January 2, 2024

Site: 7414 78th Ave SE
Mercer Island, WA 980404
TPN: 2524049075
Area: 68,825 sq. ft. = 1.6 acre

Re: RFI dated November 27th, 2023, changes itemized below, on the report and on the city response matrix highlighted in yellow.

SITE

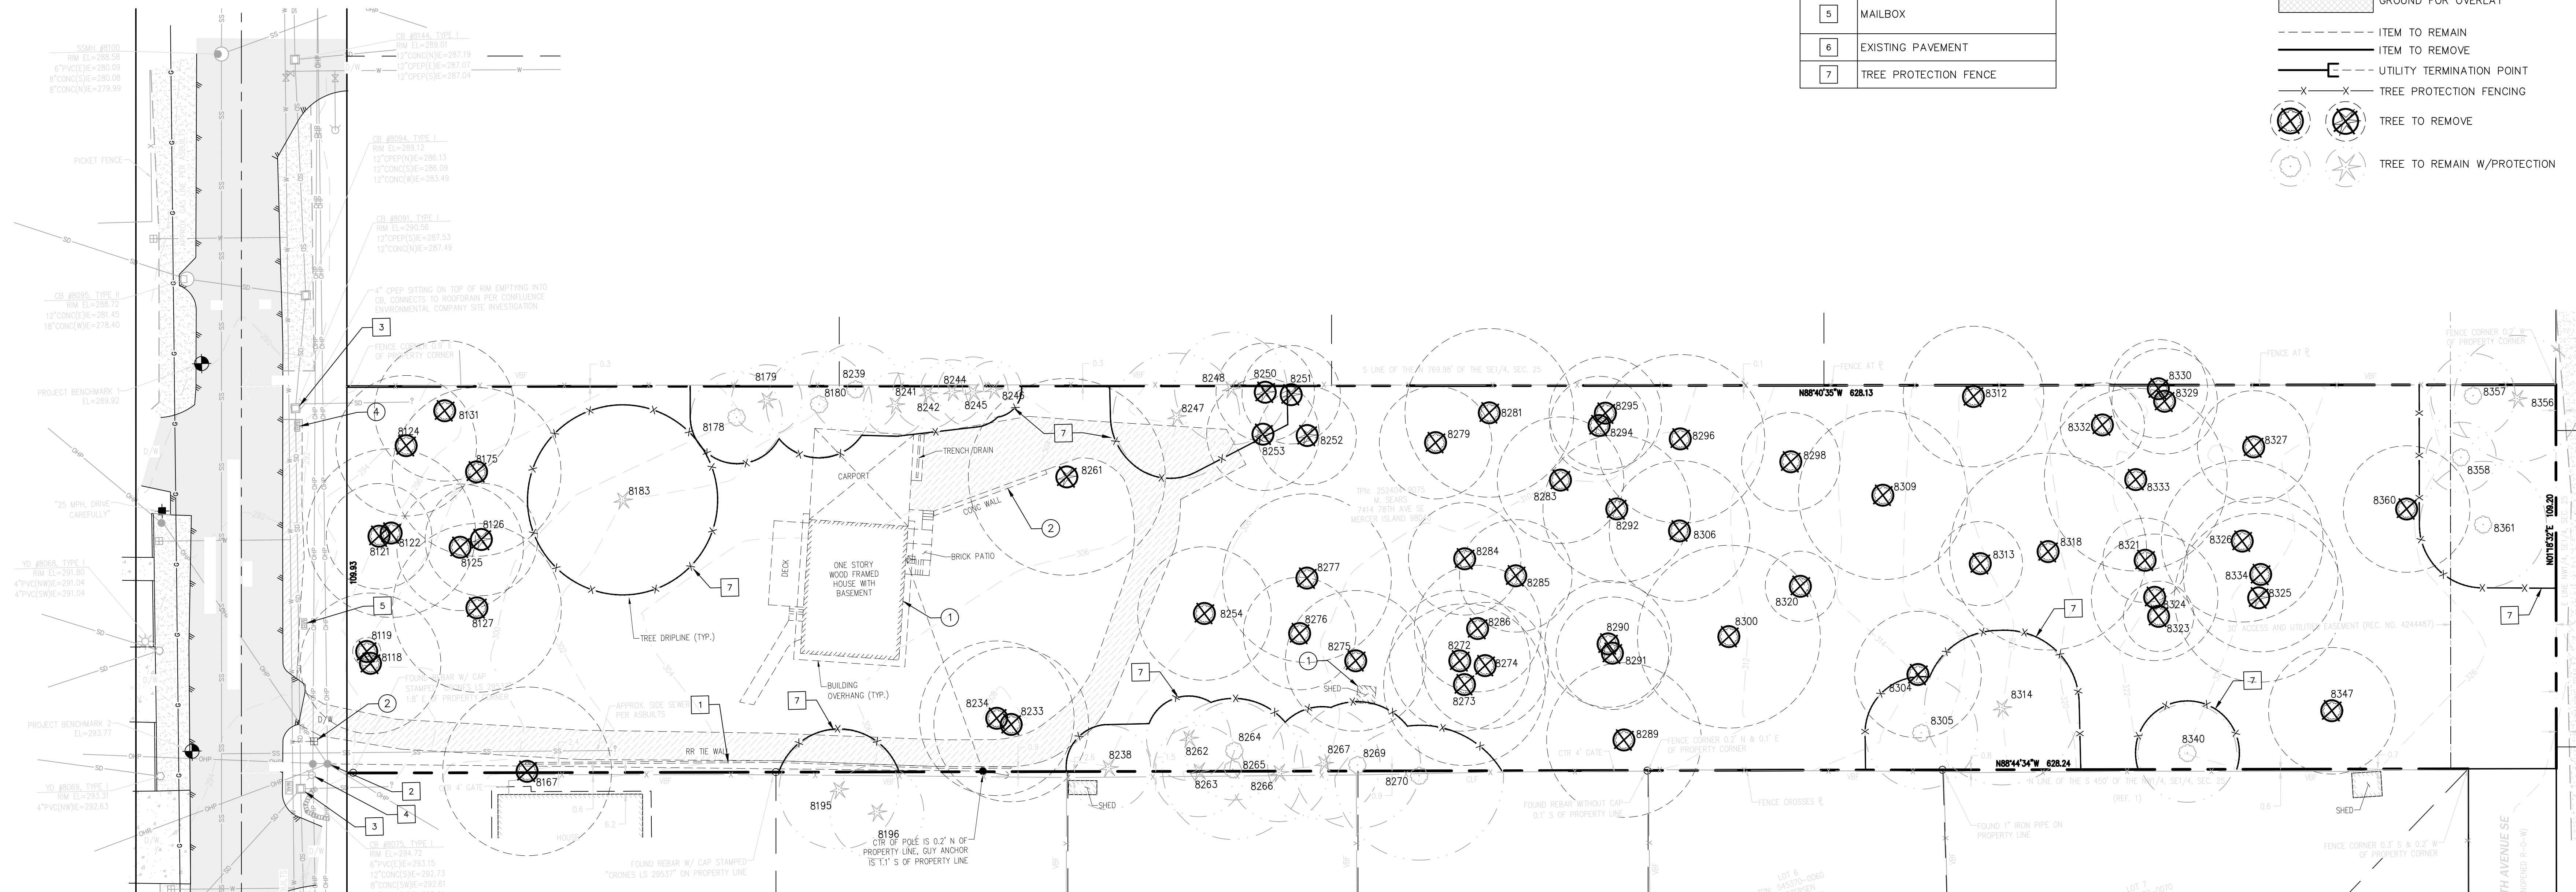
1. The tree protection shown on the site plan is right on the building pad, which would be unrealistic in the field. The building pads will need at least five feet of clearance for walking and machine access. The tree protection and limits of allowable disturbance will need to be adjusted to account for the five-foot clearance. (Building pads were reduced to allow for a 5' buffer, completed by Navix; site plan is copied and pasted onto page 21)
